PLANNING CONSULTATION RESPONSE

Application No	2026/0426
Proposal	Conversion of stable block to 1no. dwelling
Address	Land west of Cliff Lane, Brierley, Barnsley S72 9HR
Date of Consultation Reply	23 rd July 2026
Consultee	Highways DC

[2nd response]

PROPOSED GARAGE PLAN
SCALE 1:50

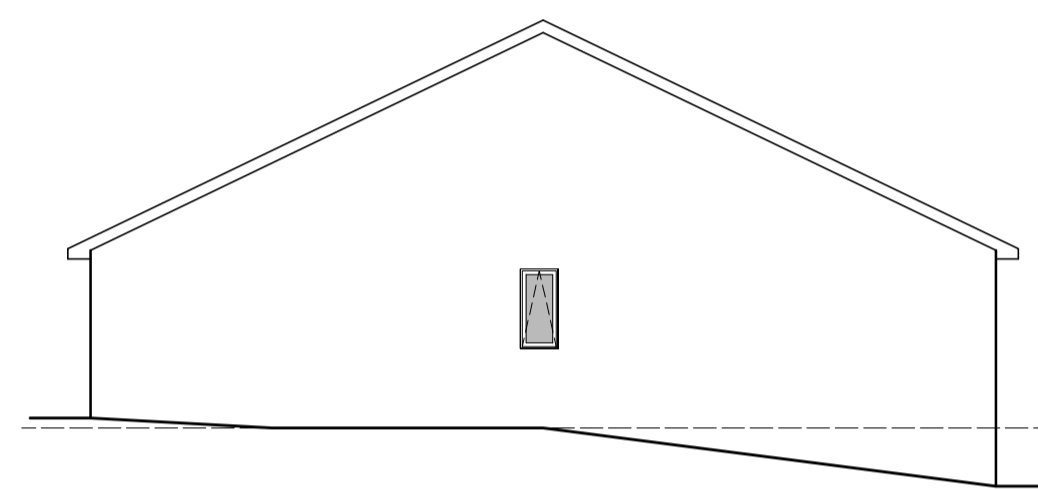
The garage shall be used for the garaging of private motor vehicles and for private use incidental to the enjoyment of the dwellinghouse only and not for trade, business or any other purposes without the grant of further specific planning permission from the Local Planning Authority.

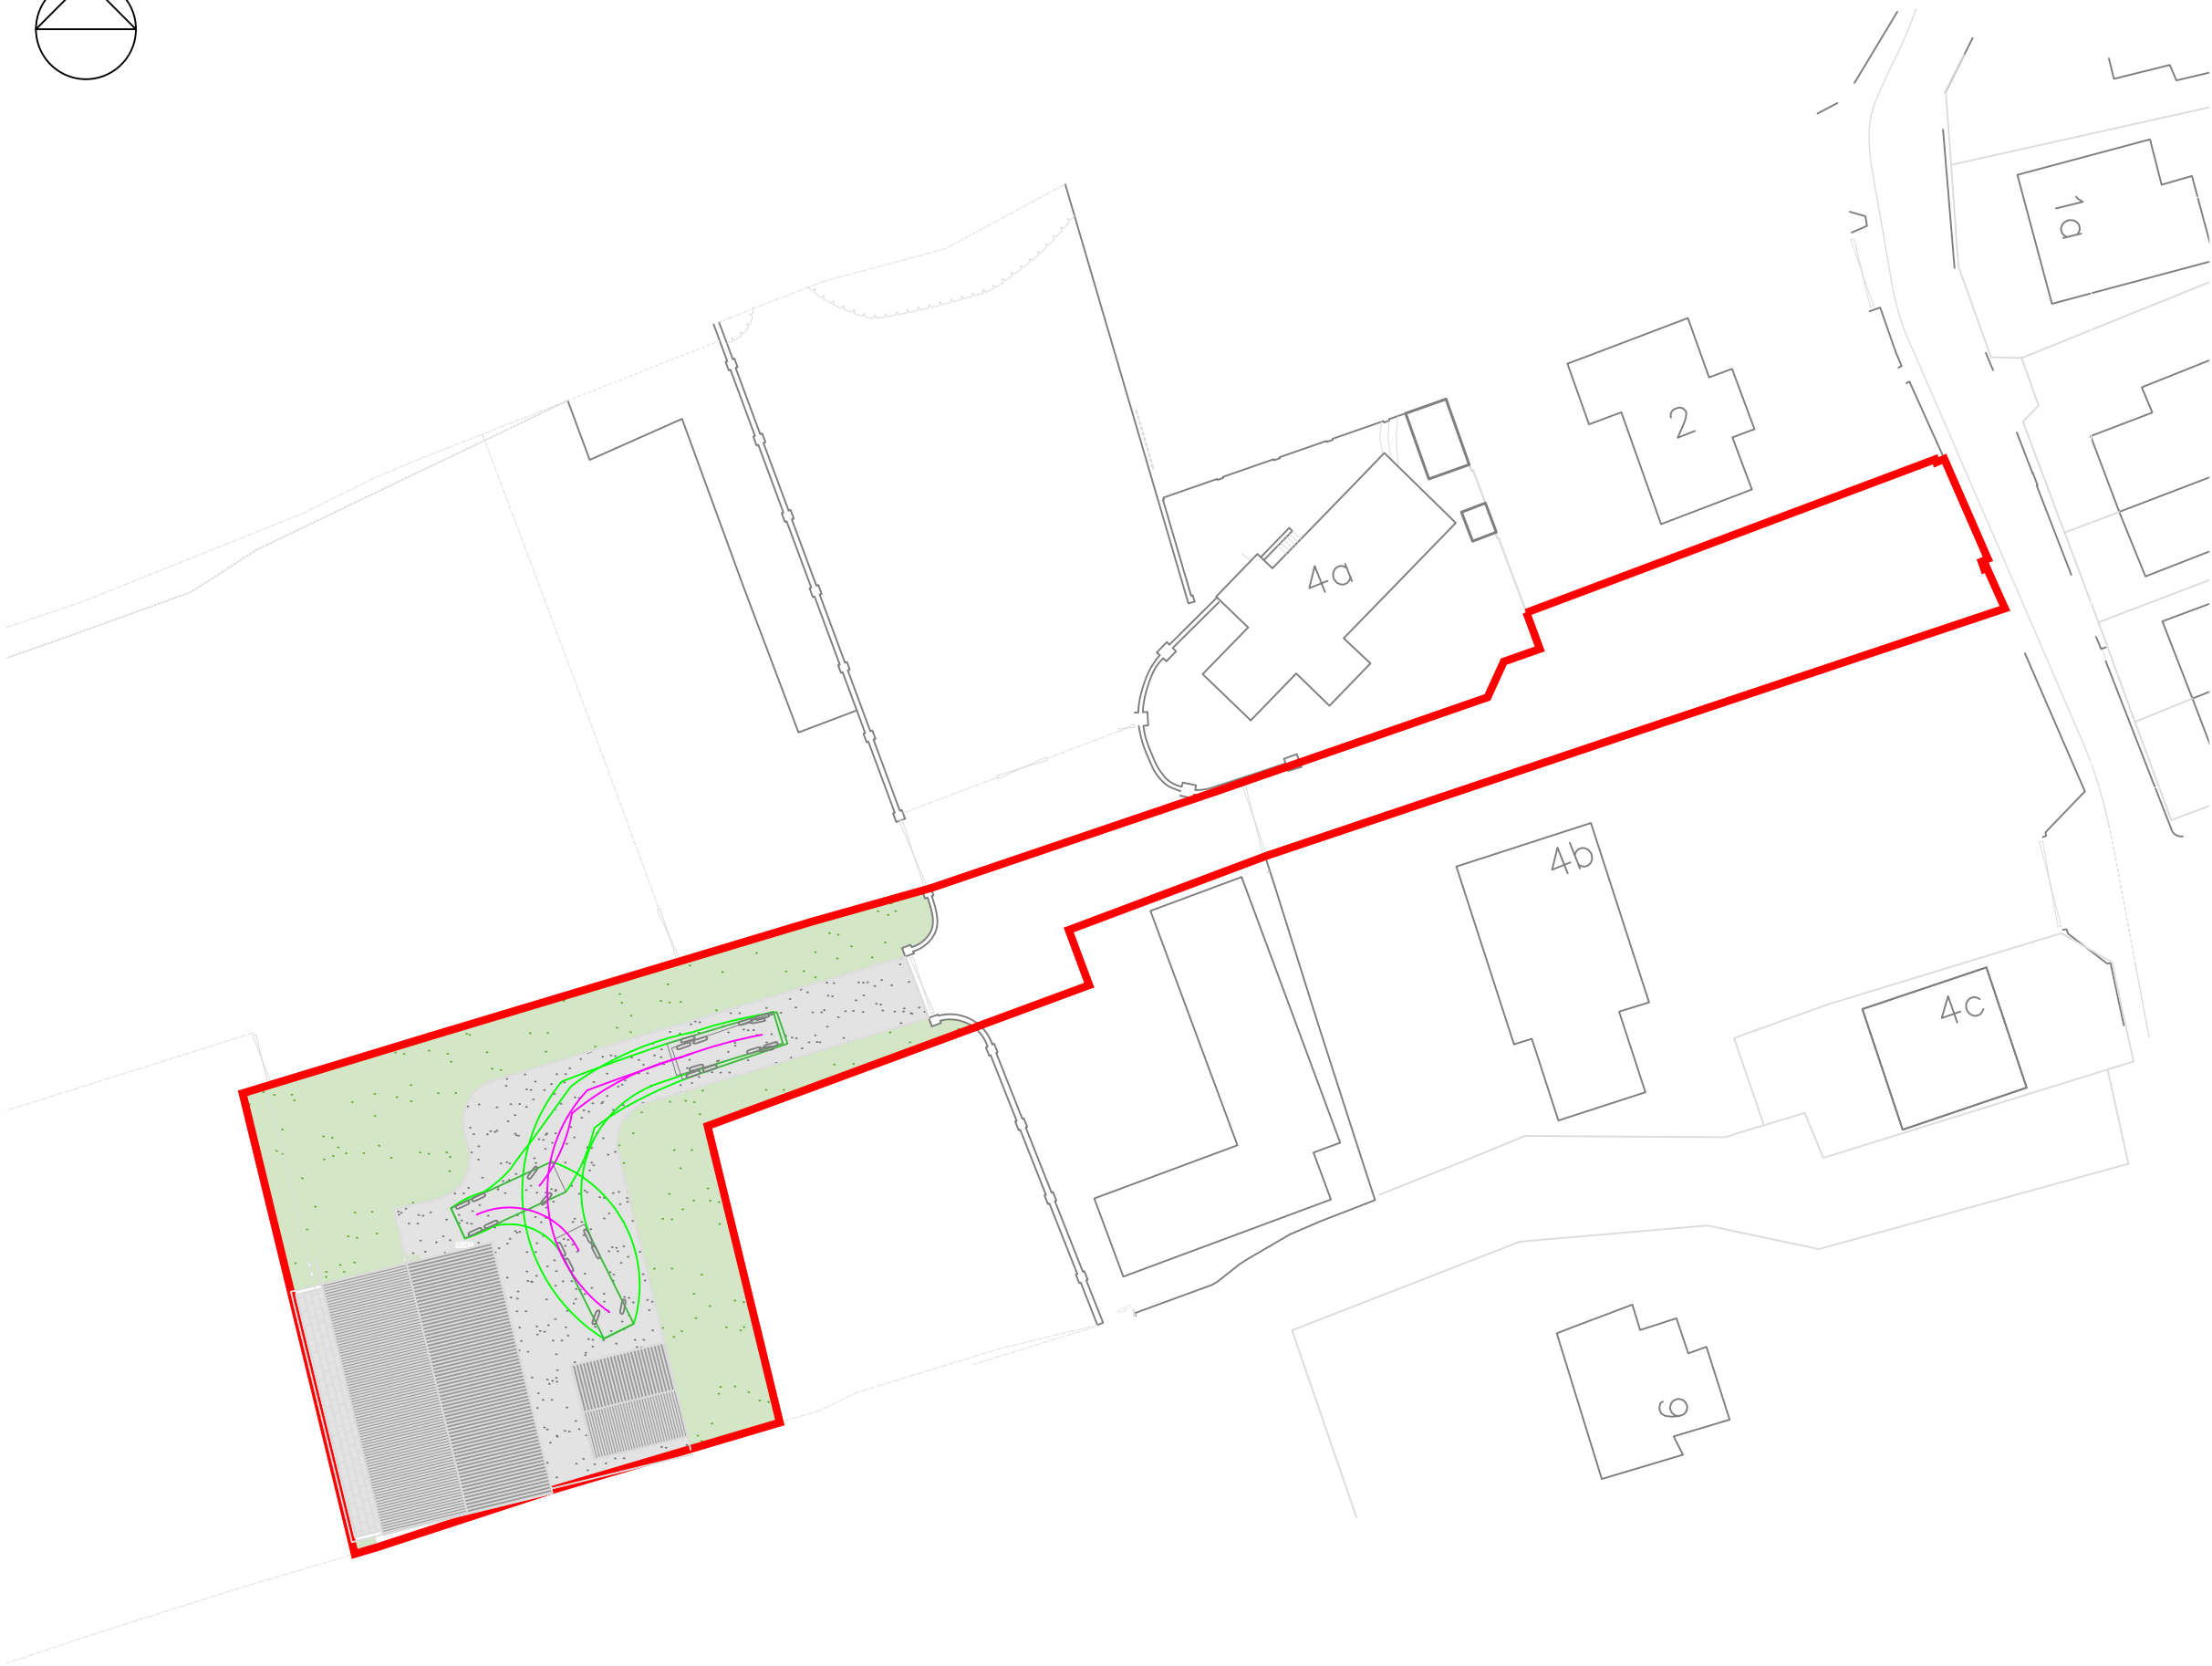
The additional information shows the location of the refuse collection and storage points, and the swept path manoeuvre demonstrates that a fire appliance can turn within the site.

The access, parking and manoeuvring facilities, indicated on the submitted plan, shall be surfaced in a solid bound material (i.e. not loose chippings) and made available for the access, parking and manoeuvring of motor vehicles prior to the development being brought into use, and shall be retained for said purposes at all times. Adequate measures shall be so designed into the proposed vehicular areas to avoid the discharge of surface water from the site on to the highway.
